Appeal Decision

Appeal Ref: 6003983

58 A Station Road, Hayes, Hillingdon UB3 4DF

EXISTING & PROPOSED PLANS

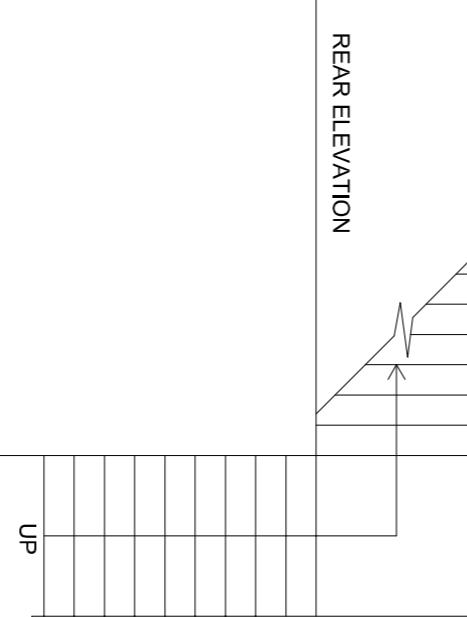
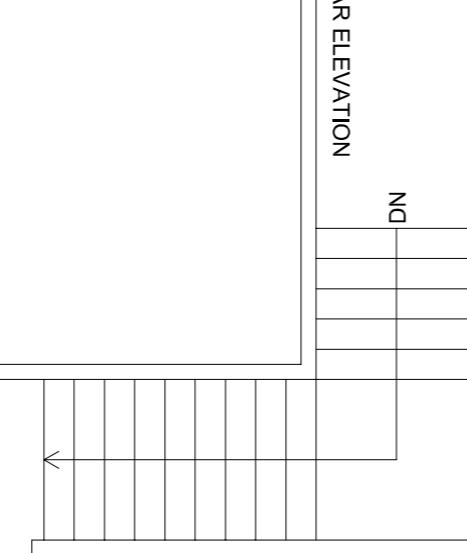
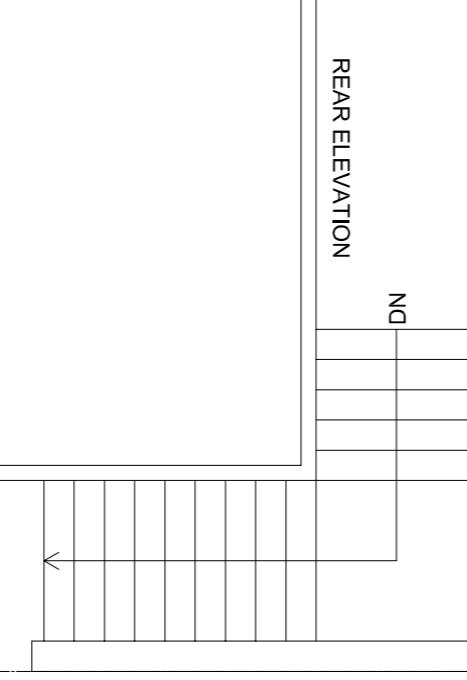
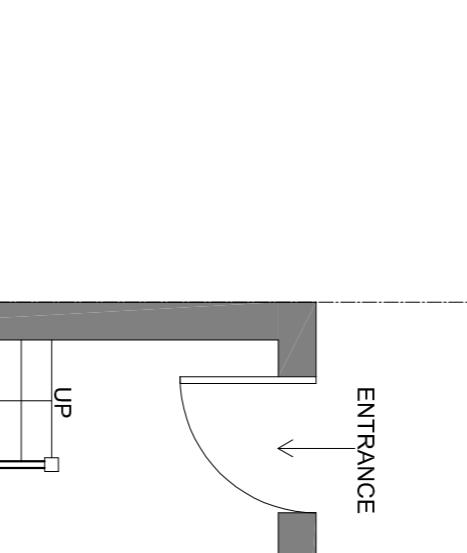
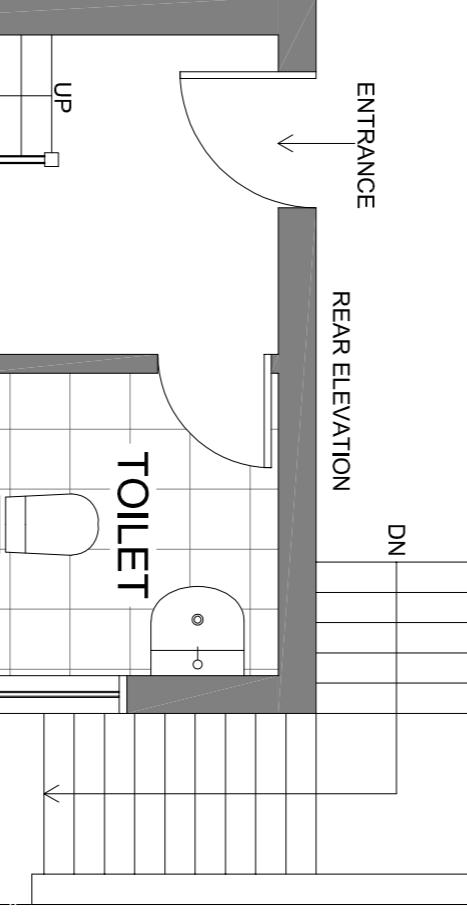
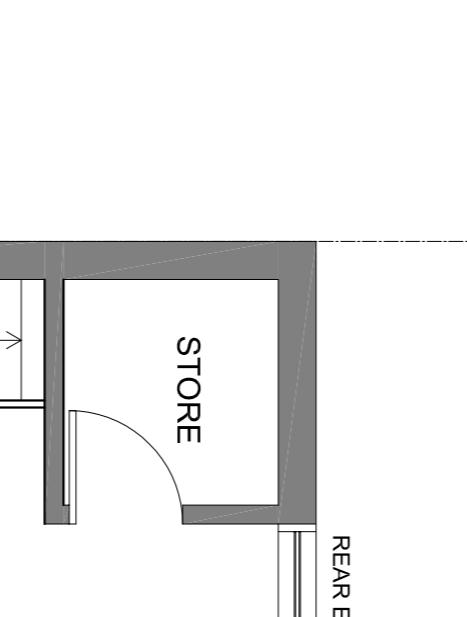
6. The appeal proposal would introduce 2 storeys of additional built form above the existing single-storey element of the property at the rear of the site. The materials would reflect those used in the existing building and surrounding area and access would, consistent with neighbouring dwellings, be via an external staircase. Nevertheless, even though the proposal would not alter the established uniformity of the Station Road frontage, it would depart from the consistent form of the terrace, appearing incongruous as a result of its height considerably greater than that of the rear elements of adjoining properties.

7. There would be limited visibility of the proposal from public vantage points, including along the Grand Union Canal Walk, as a result of the existing built form in the surrounding area and vegetation. Nonetheless, it would be visible from private vantage points and in some views from Station Road. In these views, the proposal would appear incongruous by reason of its siting at odds with the prevailing pattern of development.

9. 56A, 58A, 60A and 60B Station Road benefit from a reasonably open outlook to the rear, notwithstanding the built development at ground floor level and associated plant. Established vegetation extending above the built form adds a verdant quality to this outlook. The proposal would, through the introduction of additional built form, impinge significantly upon this outlook, eroding its openness

10. Moreover, the proposed building would, by reason of its scale and proximity to Nos 56A, 58A, 60A and 60B, appear unduly dominant in views from the rear of these dwellings, thereby appearing overbearing. Consequently, even though the dwellings are dual aspect, their outlook would be significantly diminished as a result of the proposal, to the detriment of the living conditions of occupiers. This is irrespective of the precise separation distance between the appeal proposal and Nos 56A, 58A, 60A and 60B, its height considerably less than that of the existing building and the alignment of windows consistent with those on the existing building.

12. A single window is proposed on the elevation of the dwelling facing No 58A. This window would serve a hallway. As such, the proposal would not result in overlooking of No 58A from any habitable room. In any event, the use of obscure glazing, which could be secured by condition, would ensure that the privacy of occupiers of No 58A is not eroded by the proposal.

PROPOSED FIRST FLOOR PLAN

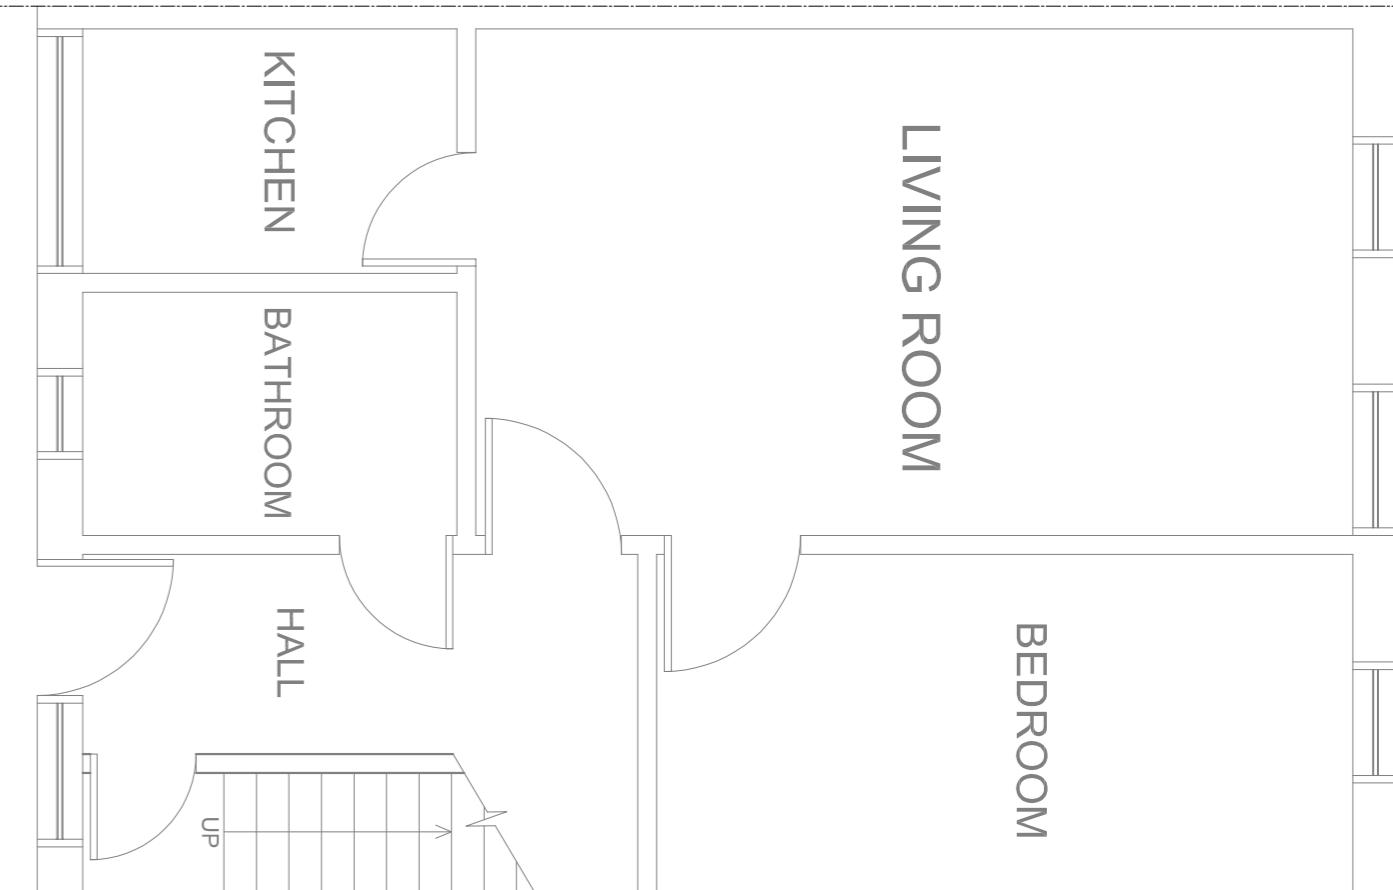
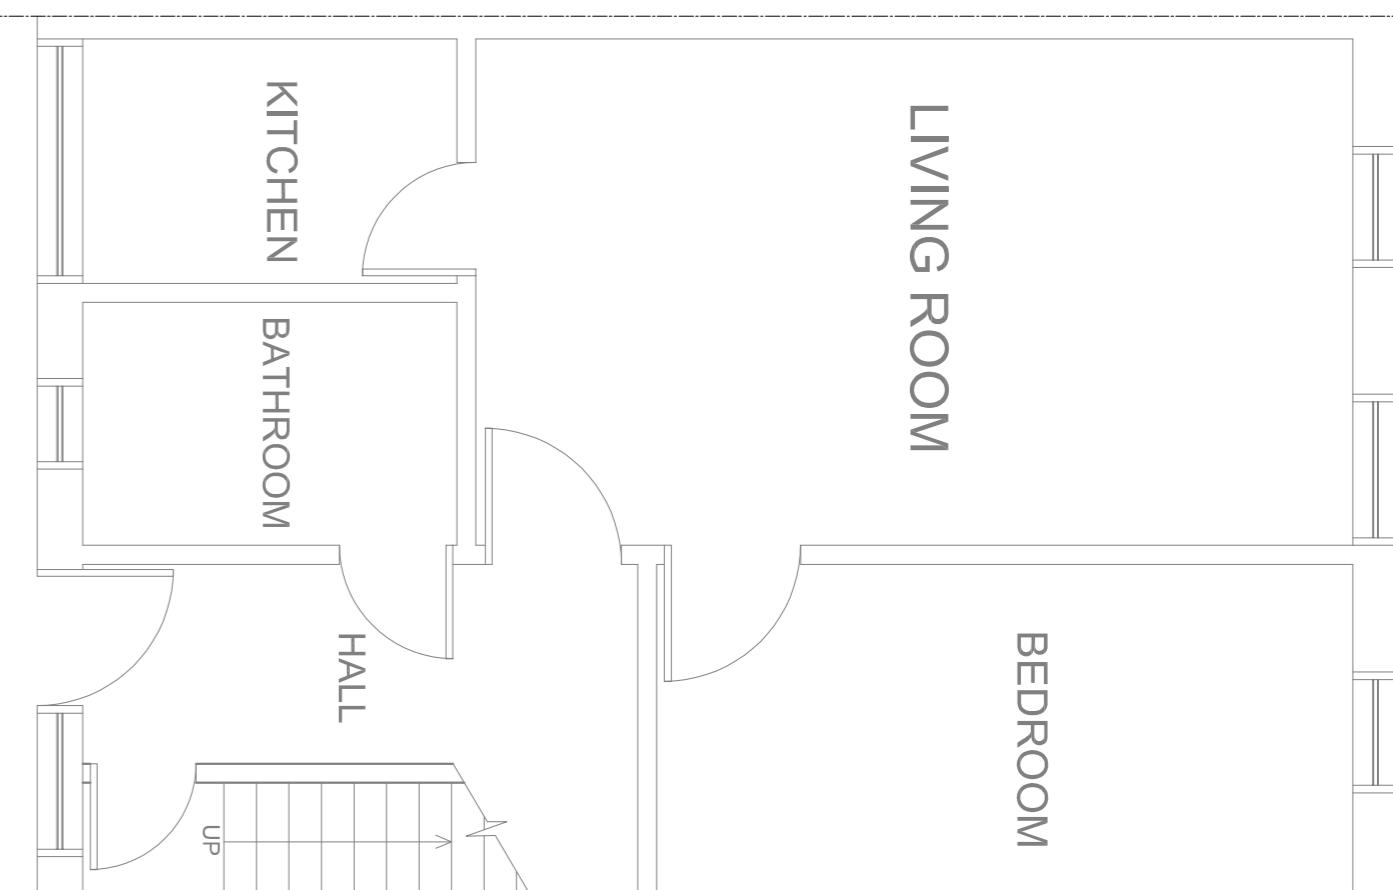
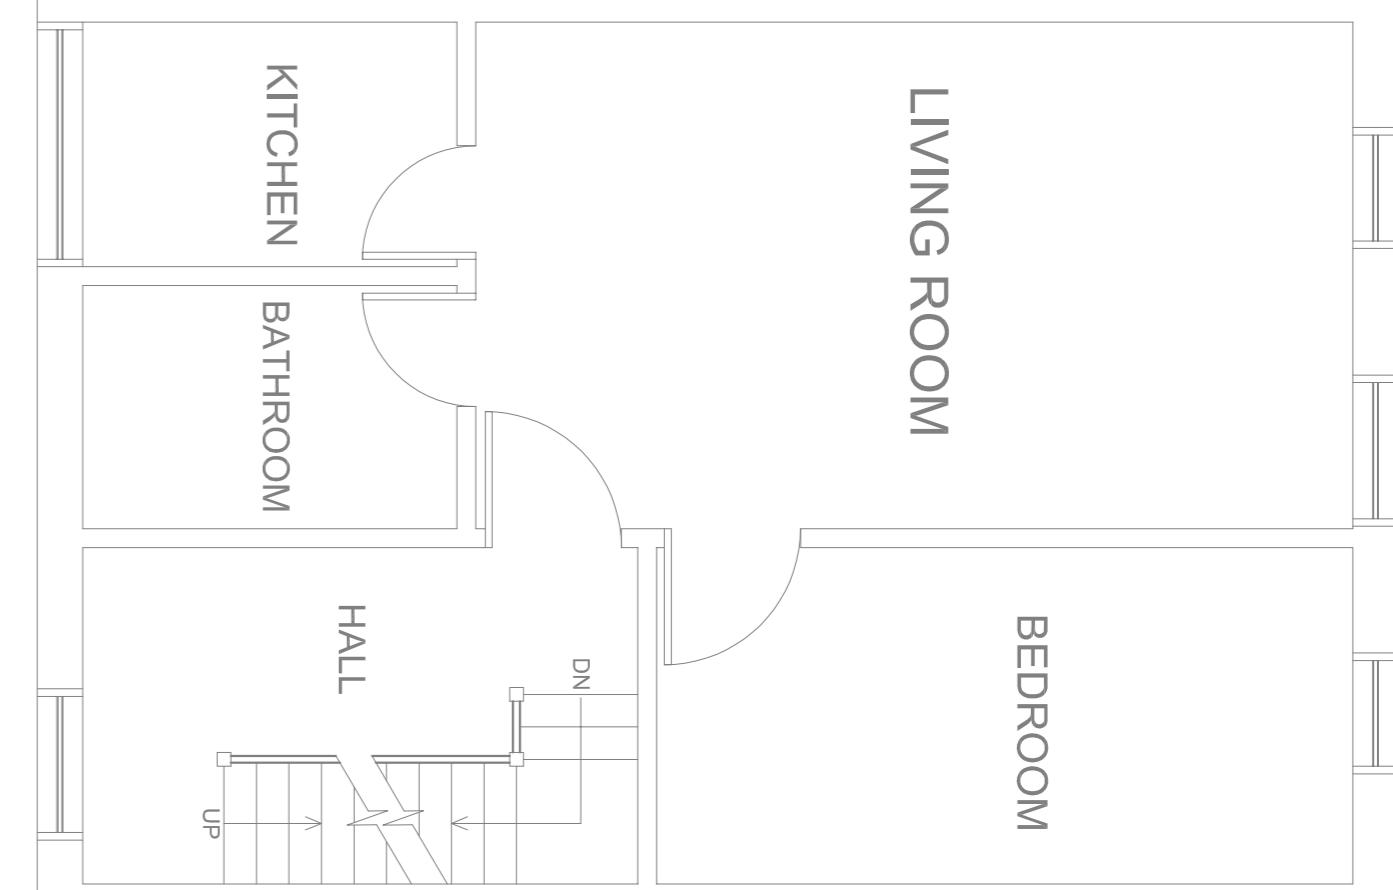
2. The appellant has submitted an amended floorplan as part of the appeal process, amending the set back from the rear boundary of the site. While the appeal process should not be used to evolve a scheme, the revised floorplan is consistent with the submitted elevations and addresses the discrepancy between the floorplan and elevations identified by the Council. In this context, and given that the Council and interested parties have had the opportunity to comment on the revised floorplan, I do not consider that any party would be prejudiced by my acceptance of the revised plan. I have, therefore, had regard to it in determining the appeal.

15. Policy DMHB 18 of the LPP2 requires that all new residential development provides good quality and usable outdoor amenity space in accordance with the standards set out in Table 5.3. For 1-bedroom flats a minimum requirement of 20sqm is identified in Table 5.3. No outdoor space is proposed as part of the development.
16. The appellant highlights that the appeal site benefits for access to nearby public green spaces including Lake Farm Country Park and Barra Hall Park. Nonetheless, the availability of public outdoor space does not entirely compensate for a lack of private outdoor space as public and private spaces are, in my experience, suitable for different uses. In this context, I am not satisfied that the lack of private outdoor space is justified, irrespective of who may occupy the proposed 1-bedroom dwelling.
